Application for a non-material amendment following a grant of planning permission. Town and Country Planning Act 1990

Single-storey rear extension

wider extension

Drg Title:
Proposed Plans

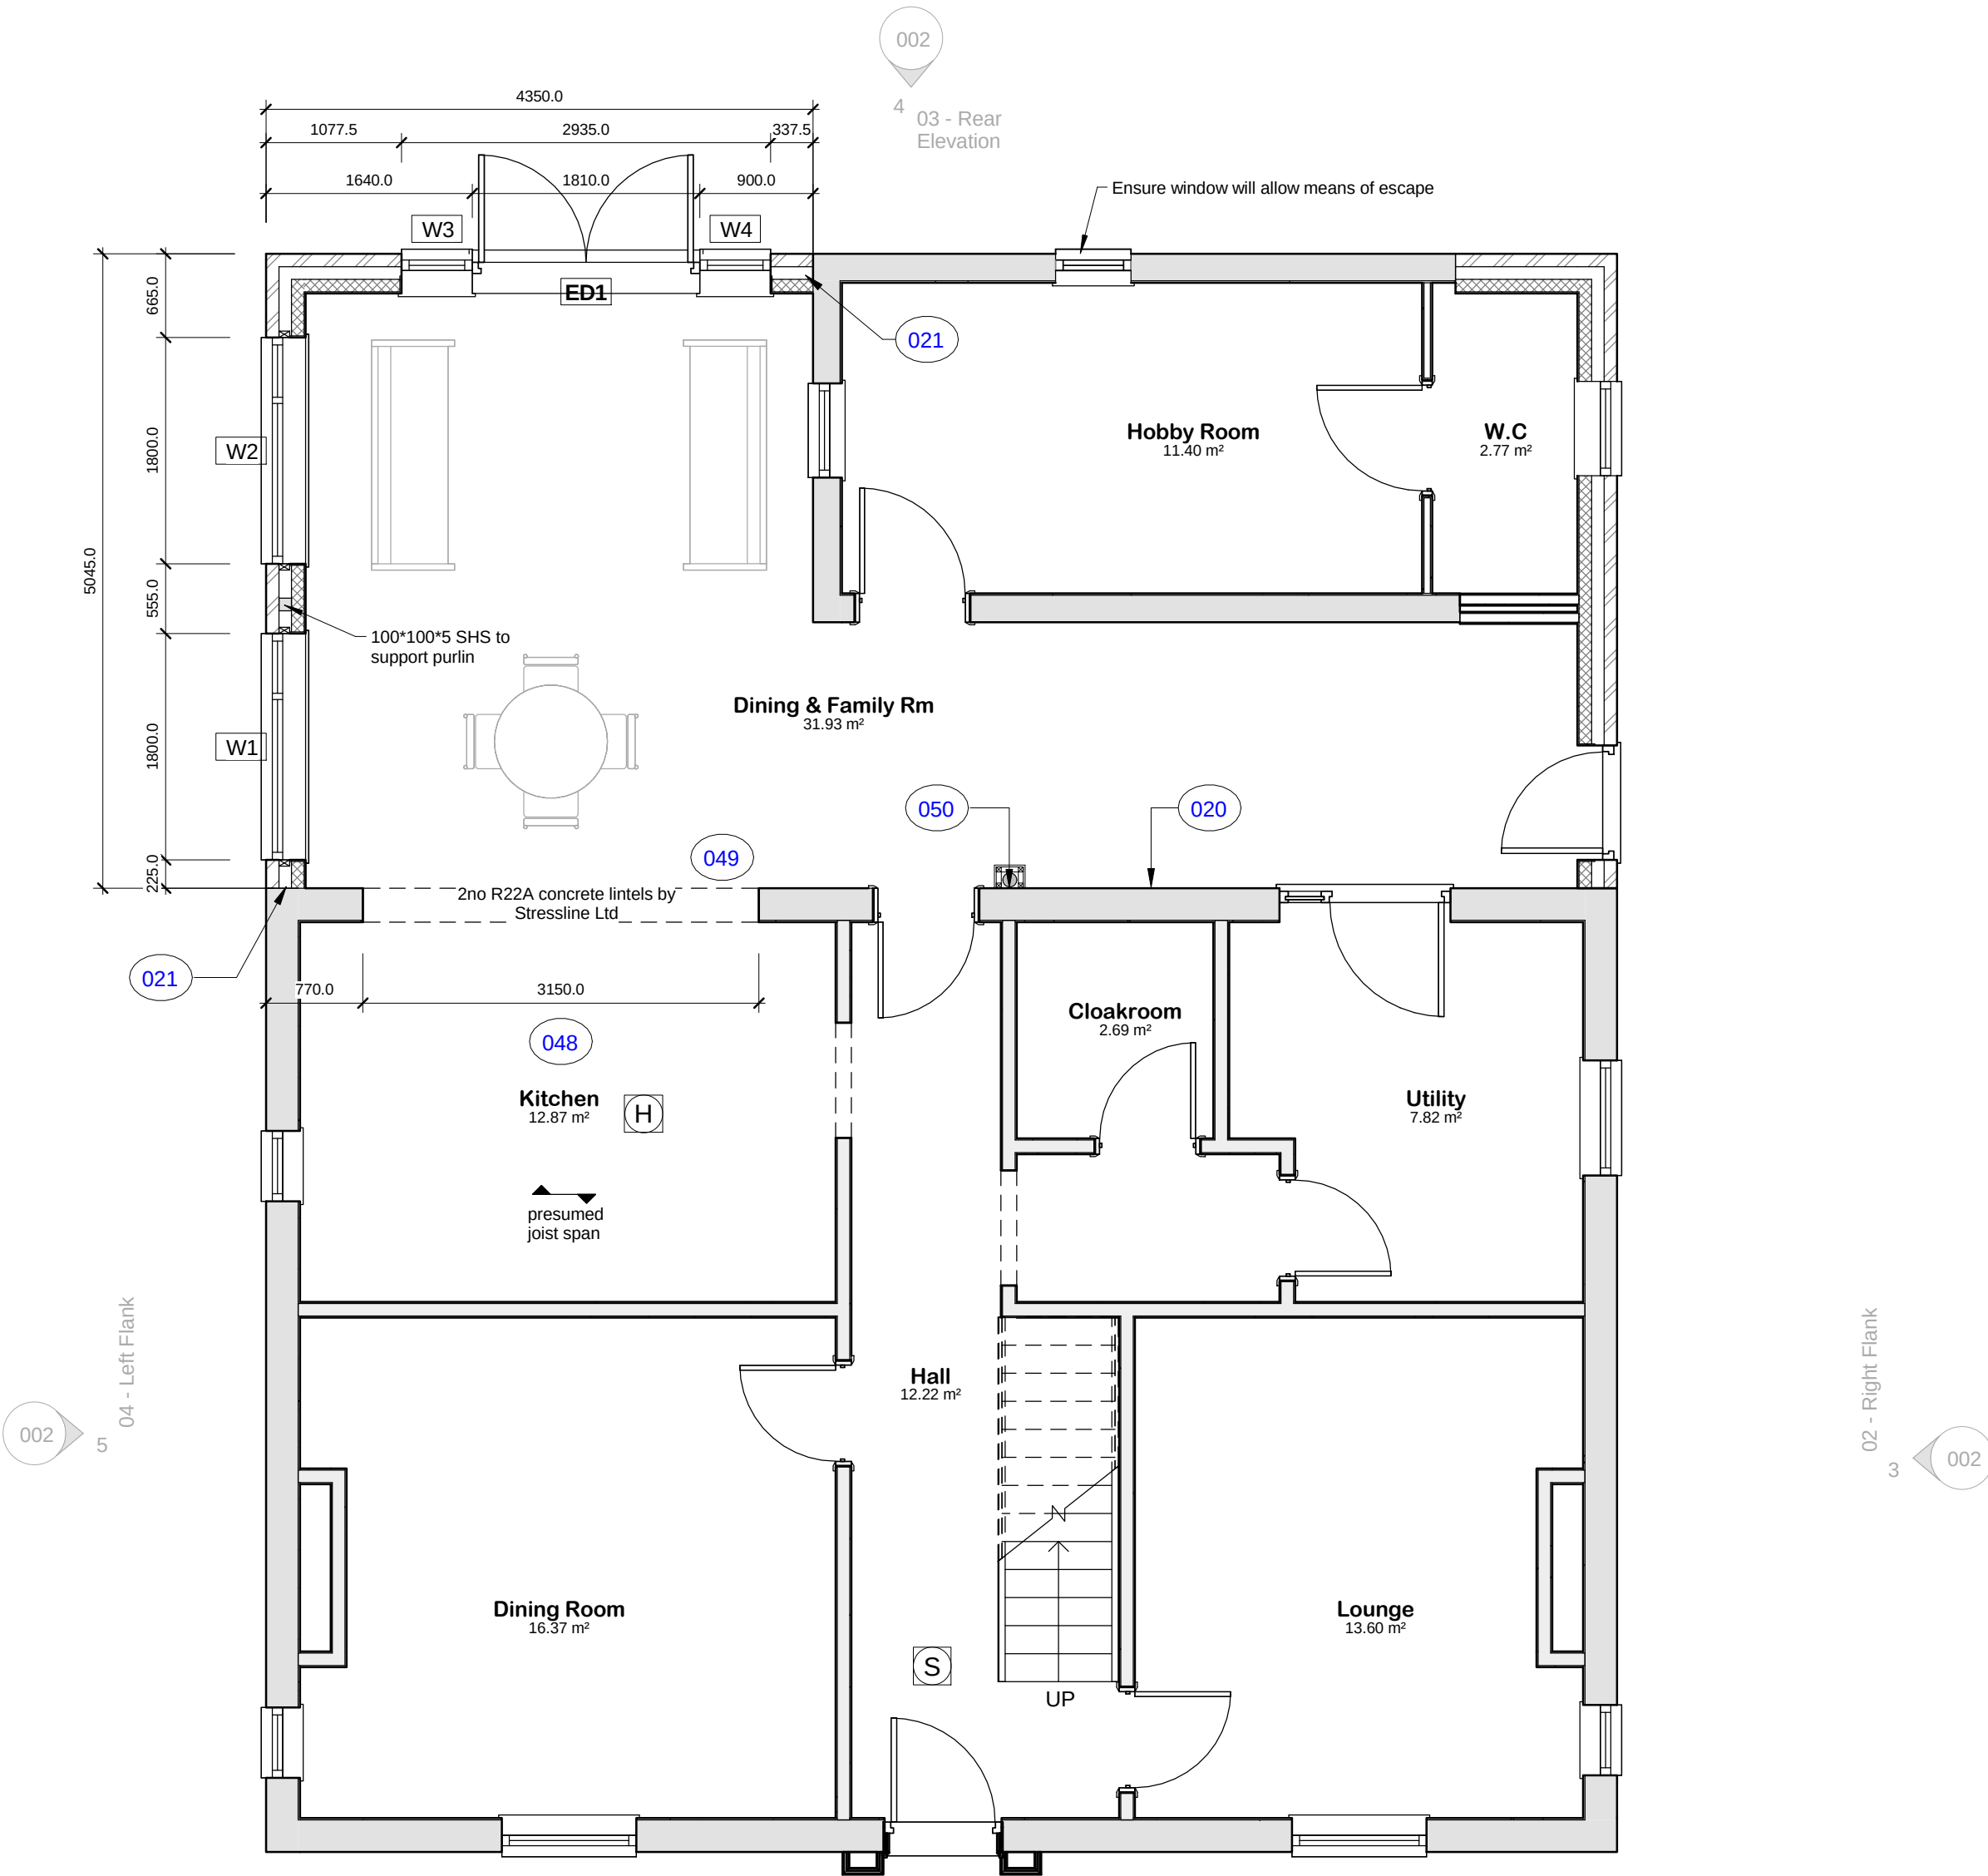
existing outbuilding has no original foundations and therefore needs to be rebuilt
